Planning Department Transportation Development Services

March 30, 2015

**Re: SEC Cross Access Driveway, 1600 Gibson Blvd. SE
Traffic Circulation Layout
Engineer's Plan Stamp Dated 3-17-15 (M15-D012D)**

Project Number 2014055  
Drawn By JW  
Checked JW  
Issue Date March 17, 2015  
Overall Site Plan

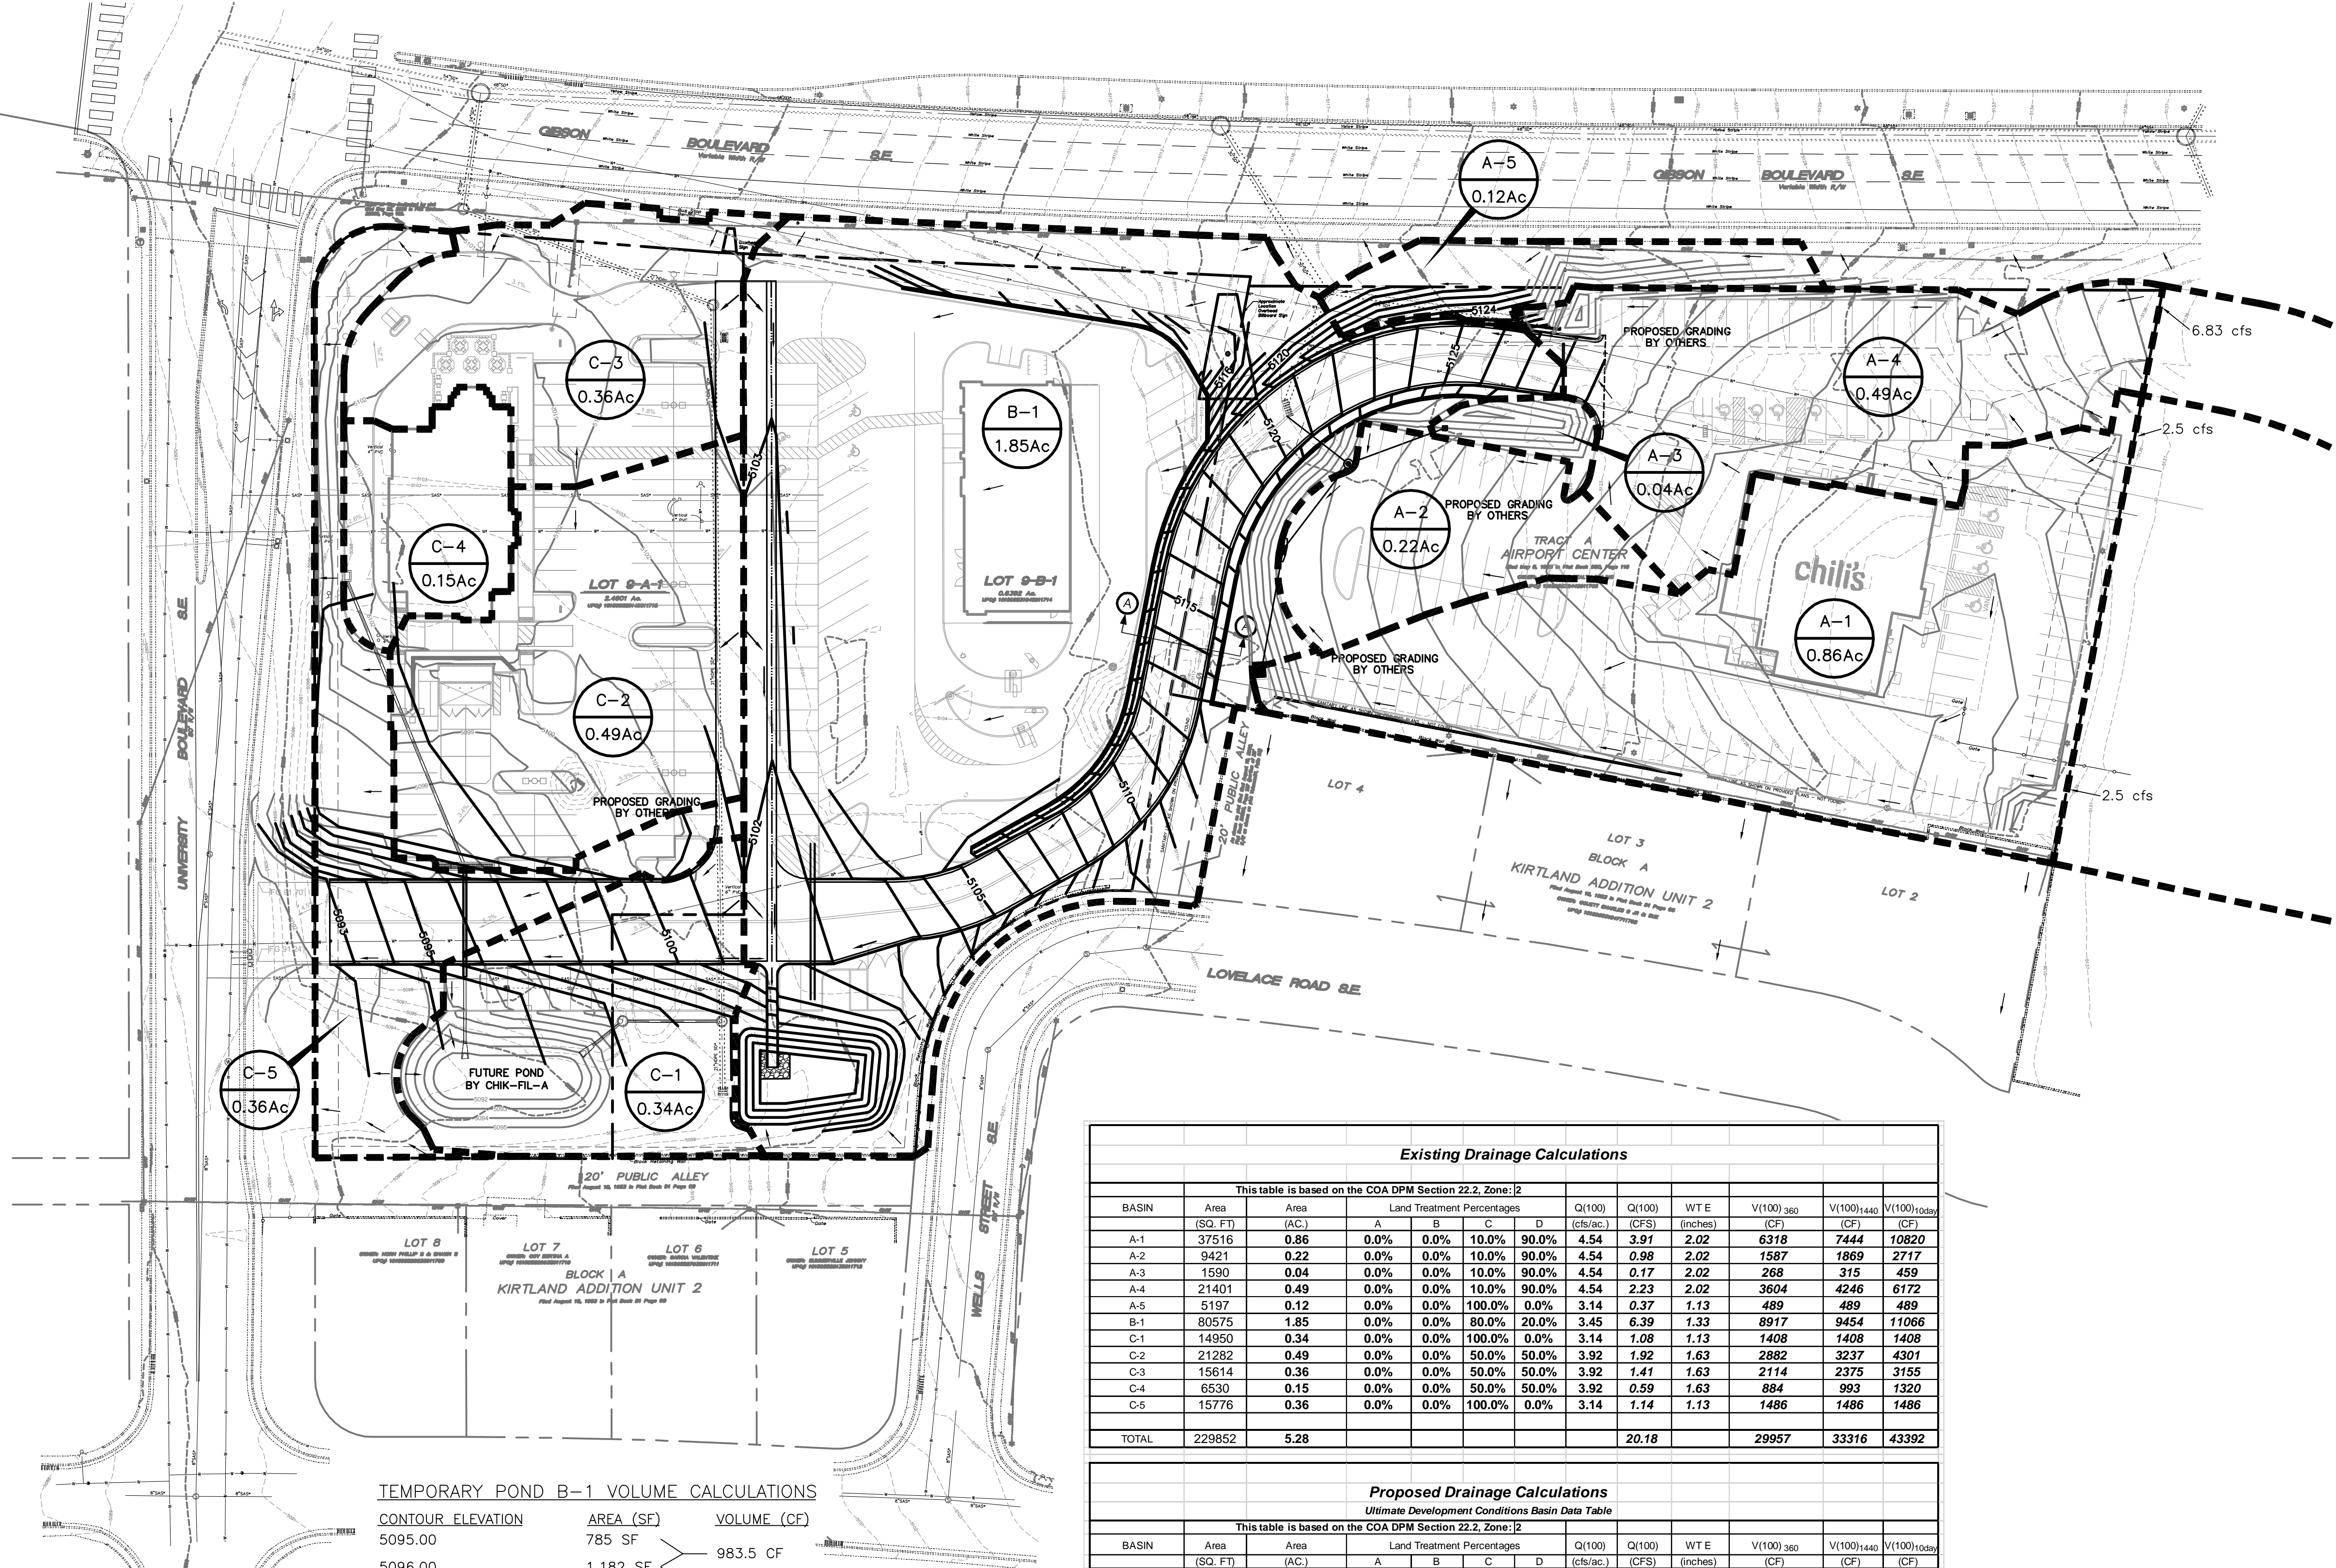
6. Provide an overall site layout for the accessway that includes the proposed site for Chili's and the tie-in to Miles Road on the east end.

Project Number 2014055  
Drawn By JW  
Checked JW  
Issue Date March 17, 2015  
Traffic Circulation  
Layout

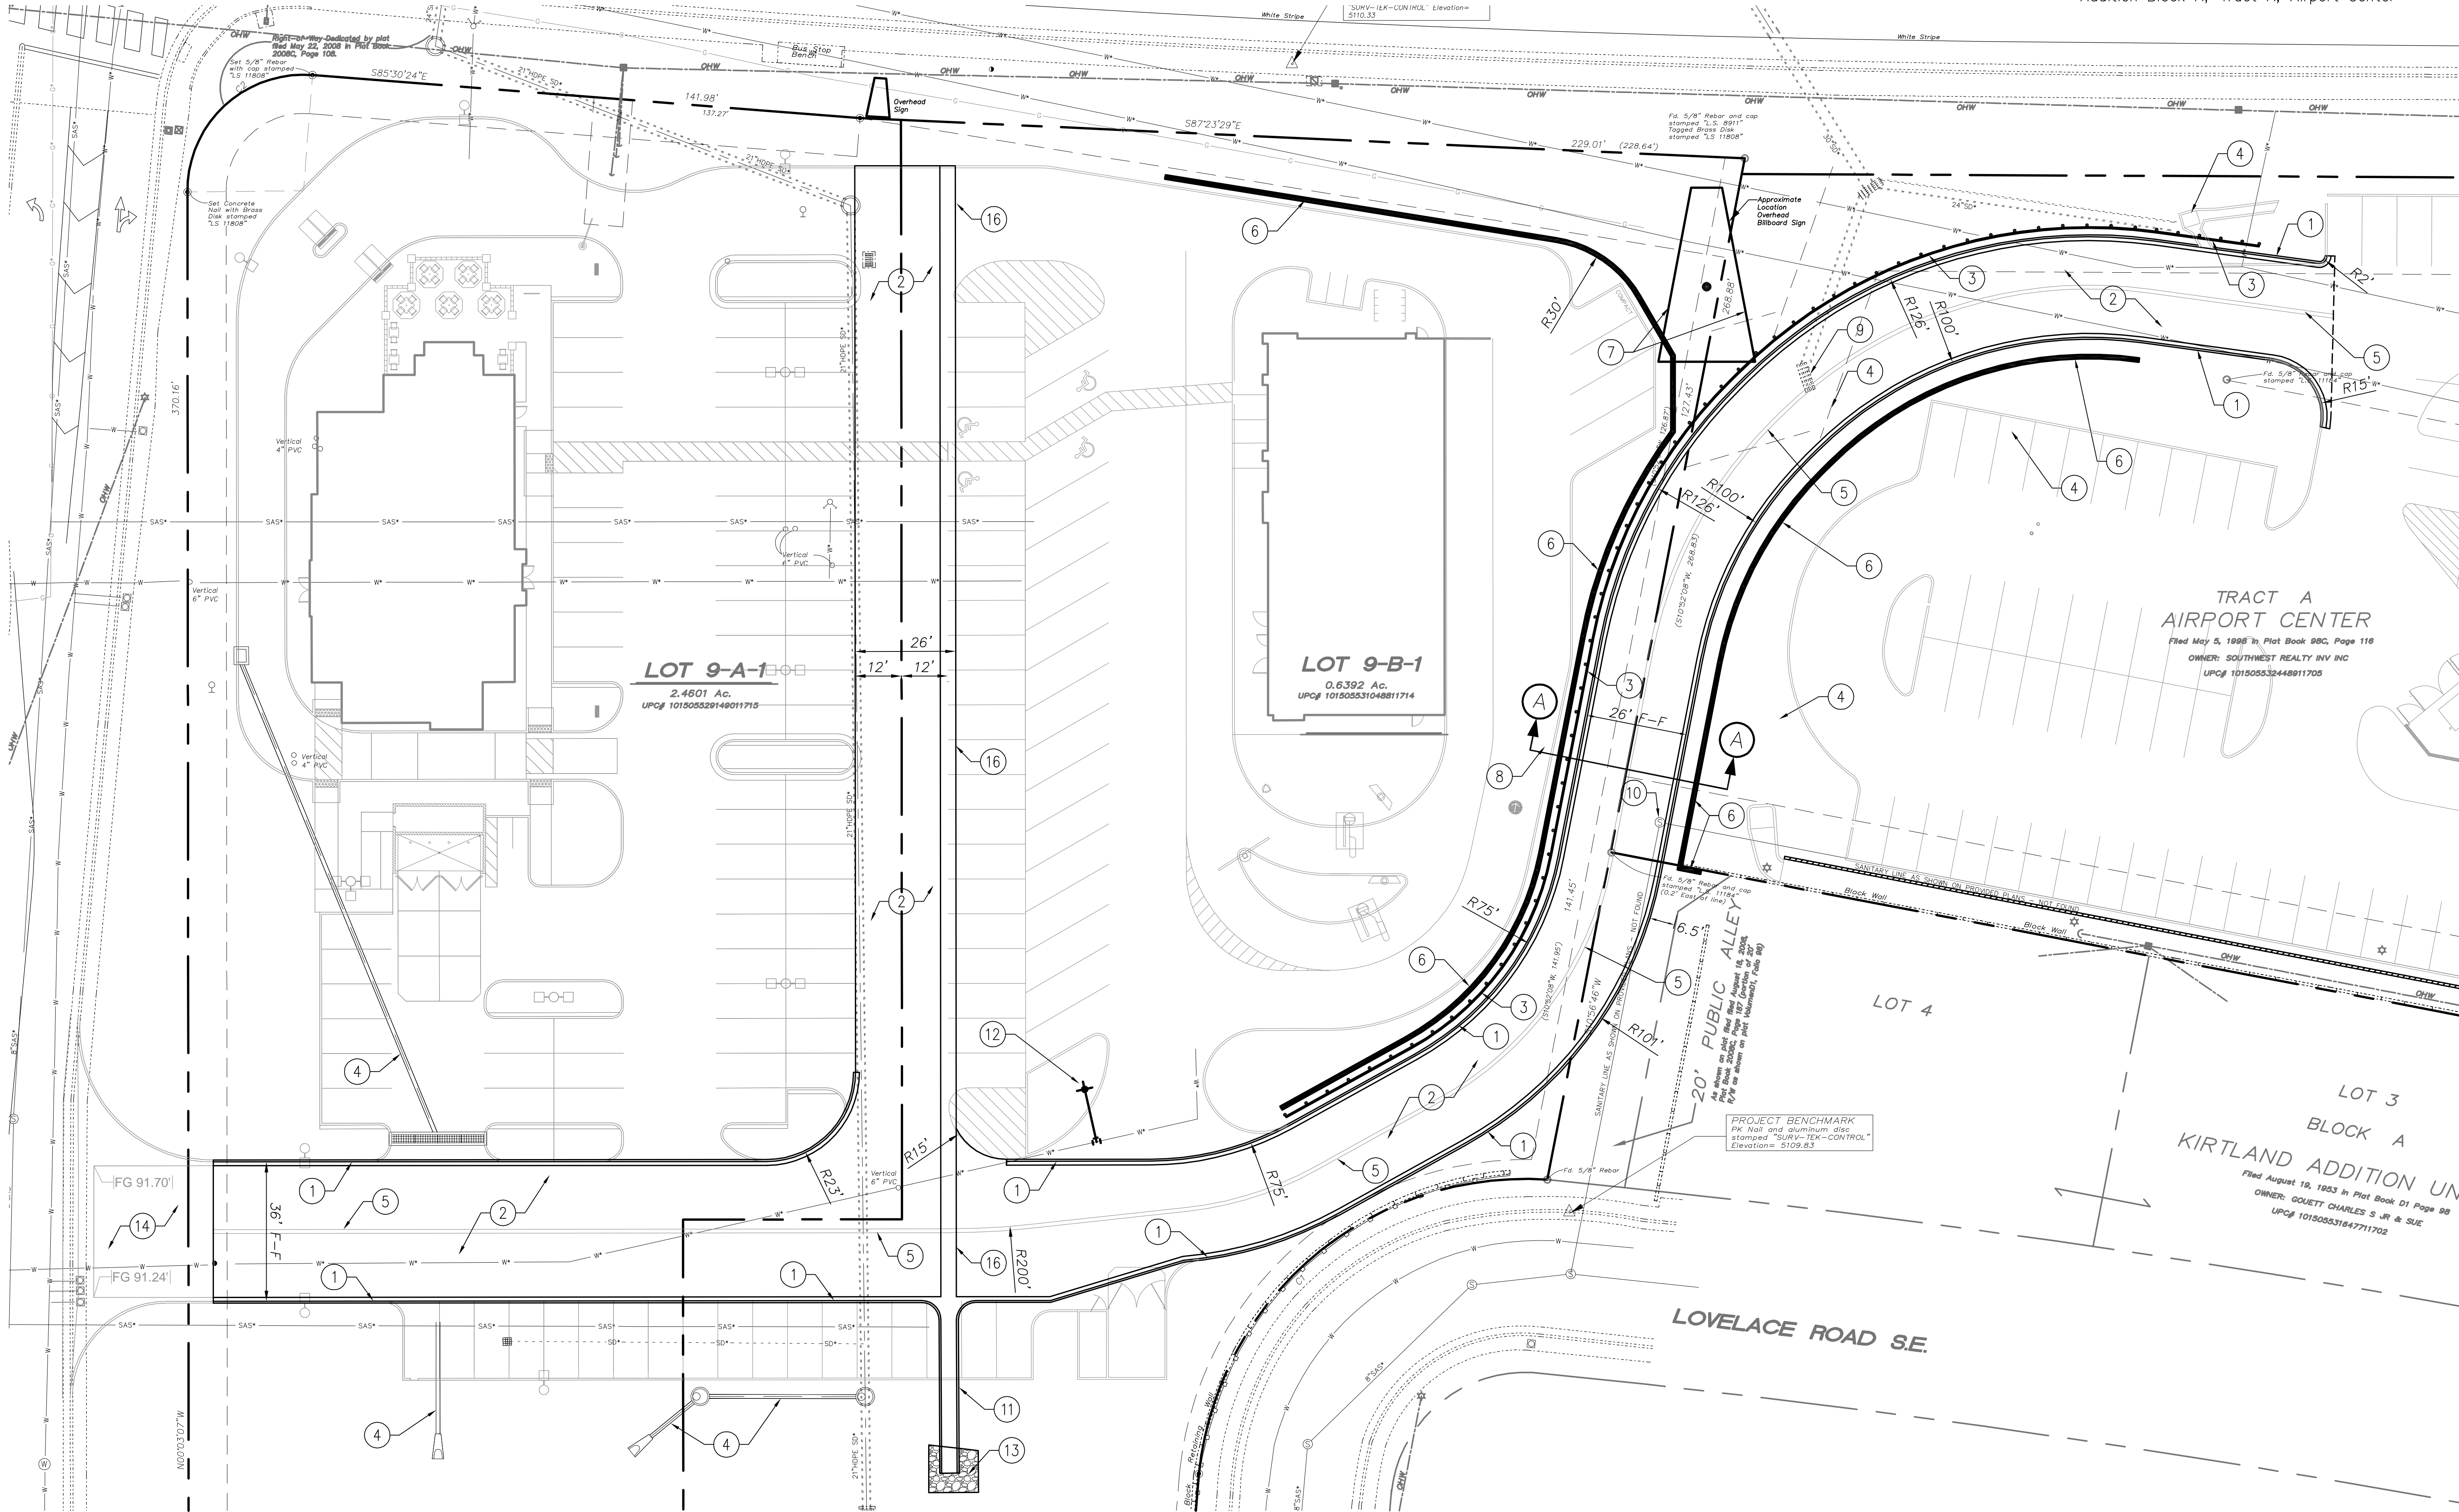
3. Clarify beginning and end of construction since this plan seems to conflict with Chick-Fil-A Construction. (For instance, a different paving section is being used for the accessway versus the Chick-Fil-A parking lot, and curb is shown along the north side of the accessway that conflicts with the parking lot access aisles into the Chick-Fil-A parking lot.)

5. East of the valley gutter where Keyed Note 16 is shown, provide a smoother curb transition by providing a radius where the accessway alignment changes.
